OXFORDSHIRE COUNTY COUNCIL'S RESPONSE TO CONSULTATION ON THE FOLLOWING DEVELOPMENT PROPOSAL

Application no: 24/00375/F

Proposal: Formation of two fishing lakes, two nursery lakes, the siting of 15 accommodation lodges, 8 pods, a management building and ancillary vehicular access, parking and landscaping

Transport Development Control

Plan

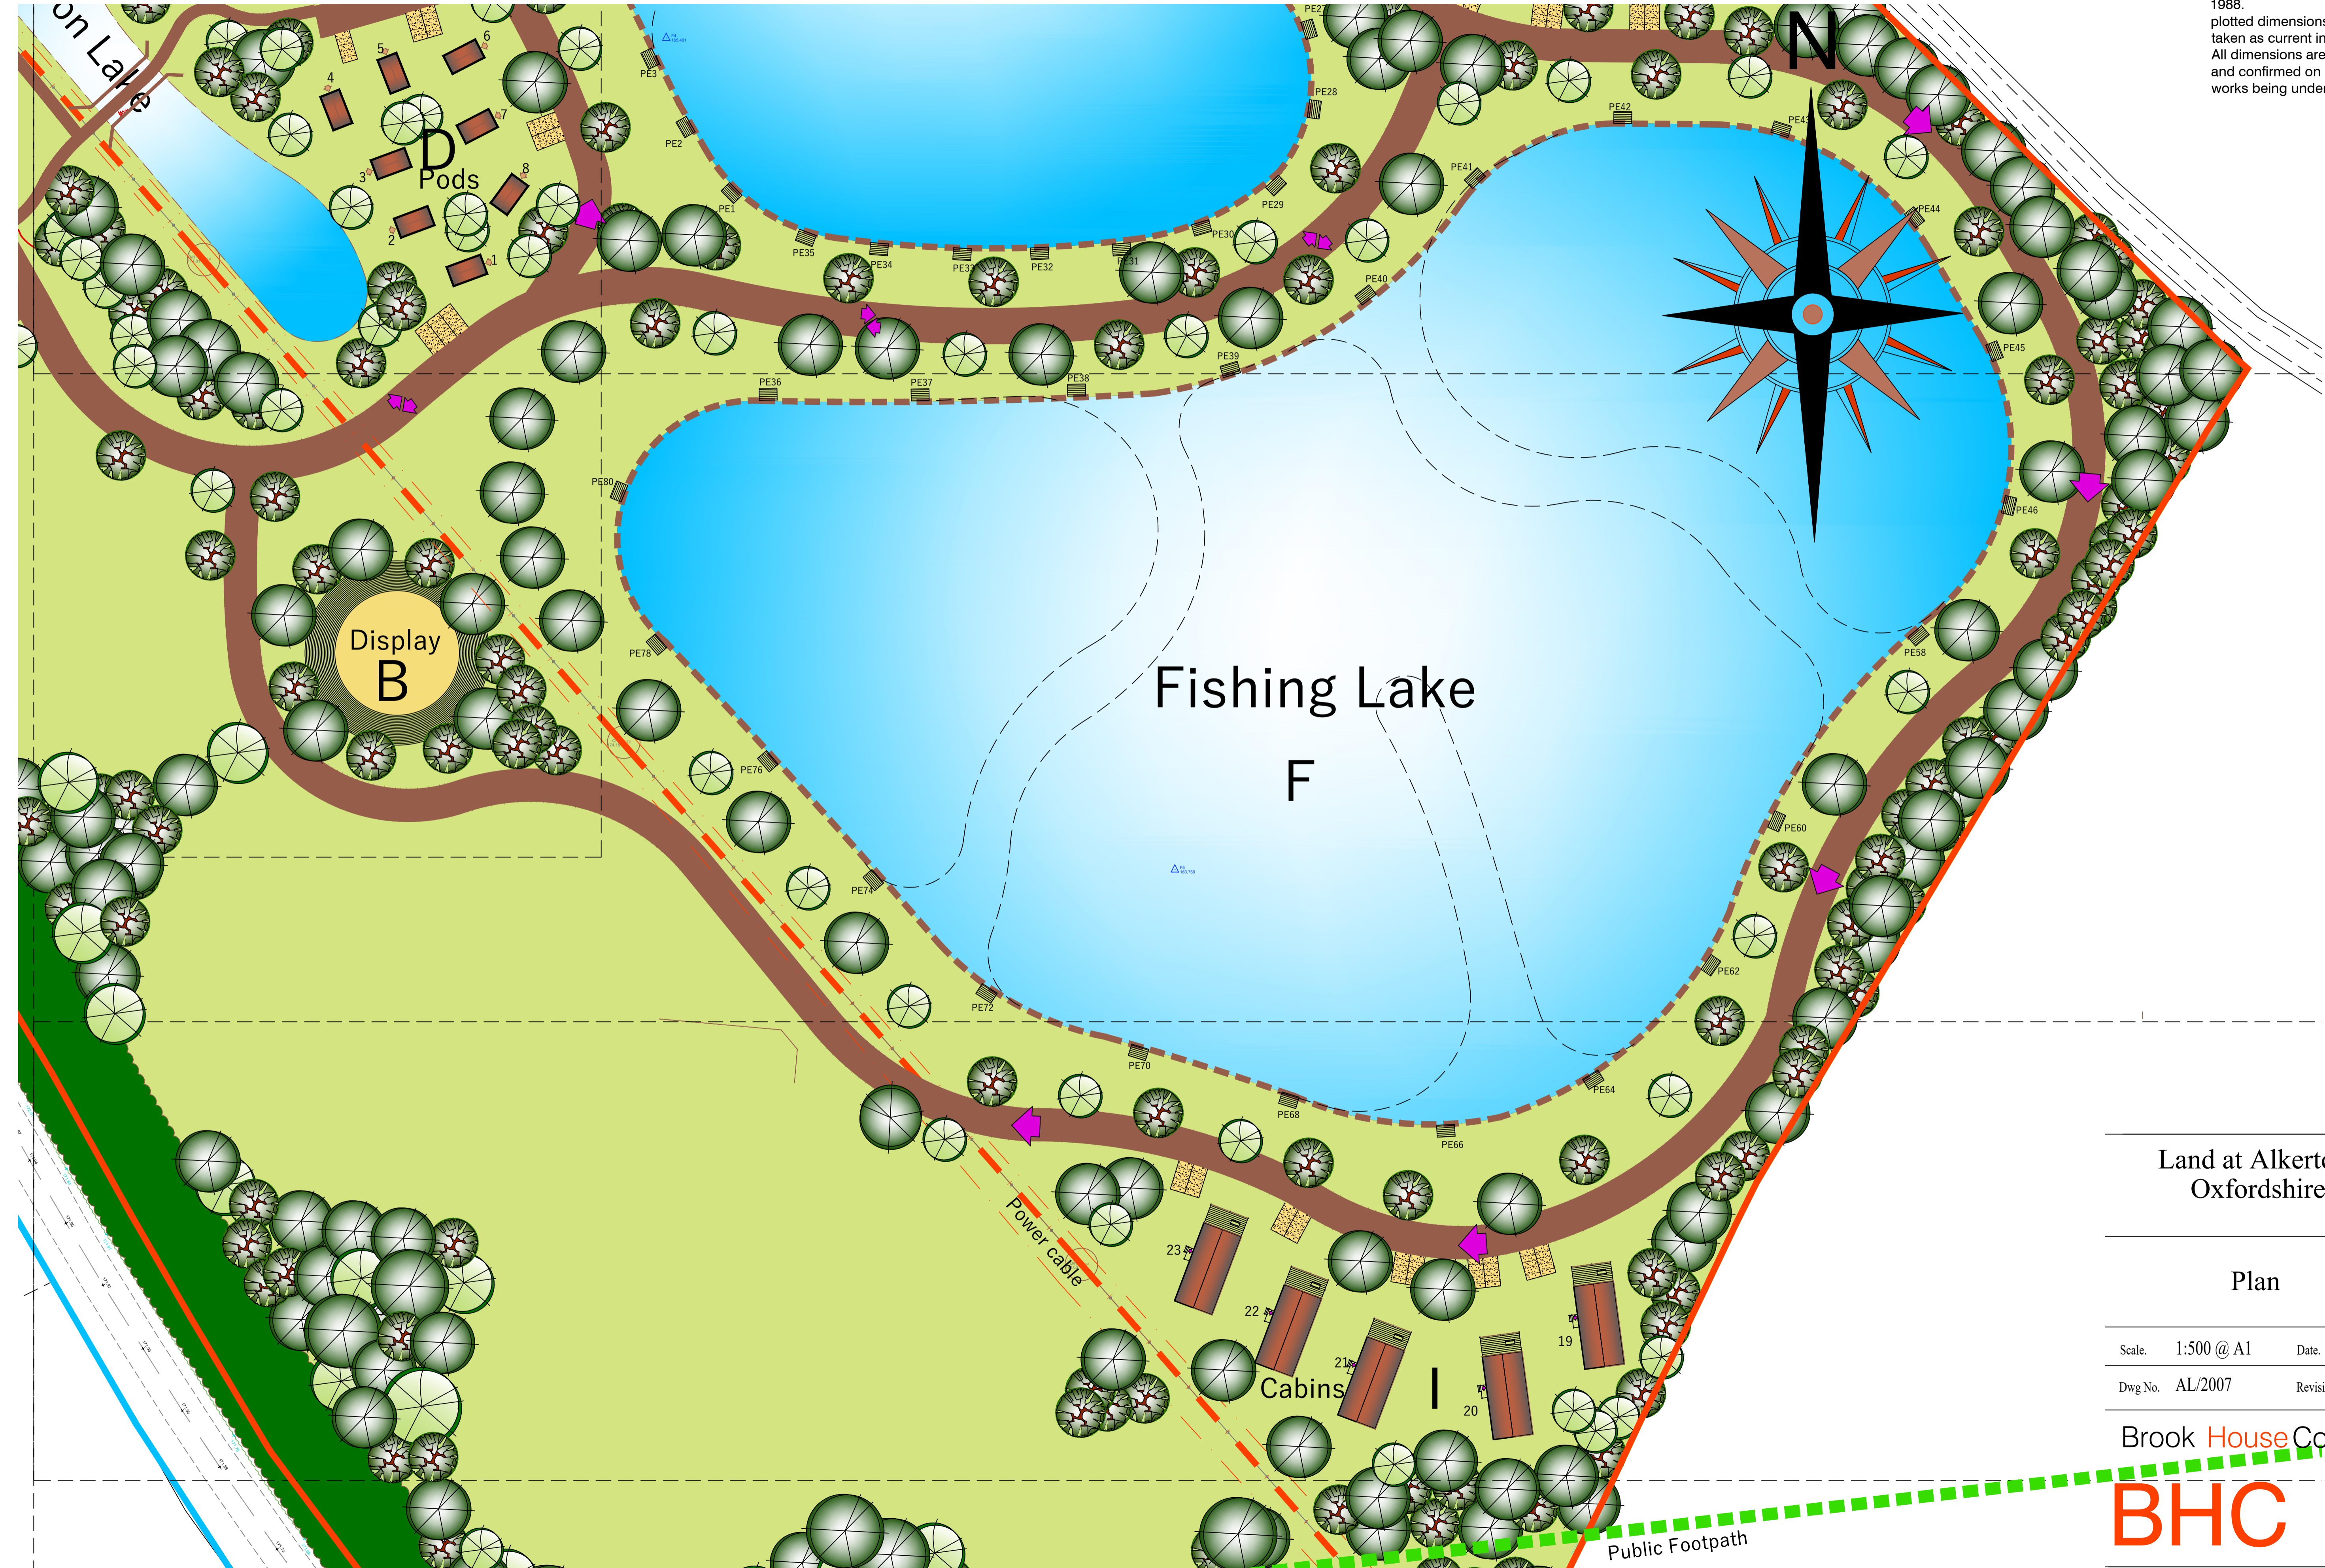
The access road includes a side road providing access to the car park. However, this road extends beyond the car park and terminates at the bridge under the A422 carriageway. It has not been explained why this road has been extended beyond the car park and it is considered that this layout is confusing for visitors exiting the car park. As there is no turning head, it would mean that vehicles that mistakenly turn right out of the car park would have to reverse back. Clear signage or a turning head is required, in line with MfS guidance.

This is a full planning application, however, the Access Appraisal states in paragraph 4.8: *Further consideration of the proposed internal layout will be given as the layout progresses, including traffic calming techniques along the private access road to support the shared surface environment. This could include the use of raised tables at key internal junctions, chicanes at regular intervals and carriageway narrowing to reduce vehicle speeds."*

A full planning application should include drawings and swept path analyses of the internal access roads. It is therefore considered that insufficient information has been provided to determine whether the internal layout is acceptable.

A total of 60 car parking spaces have been proposed for the 81 fishing pegs, 23 holiday lodges and up to 6 members of staff. The applicant has not provided evidence for the proposed number of spaces. The level of parking proposed needs to be evidenced and justified and it is therefore considered that a parking accumulation study is required.

No EV charging points have been proposed. The adopted OCC Parking Standards for New Developments document, states that 25% all car parking should include active charging points.

No cycle parking spaces have been proposed. Cycle parking should be in line with guidance provided in the OCC Parking Standards for New Developments.
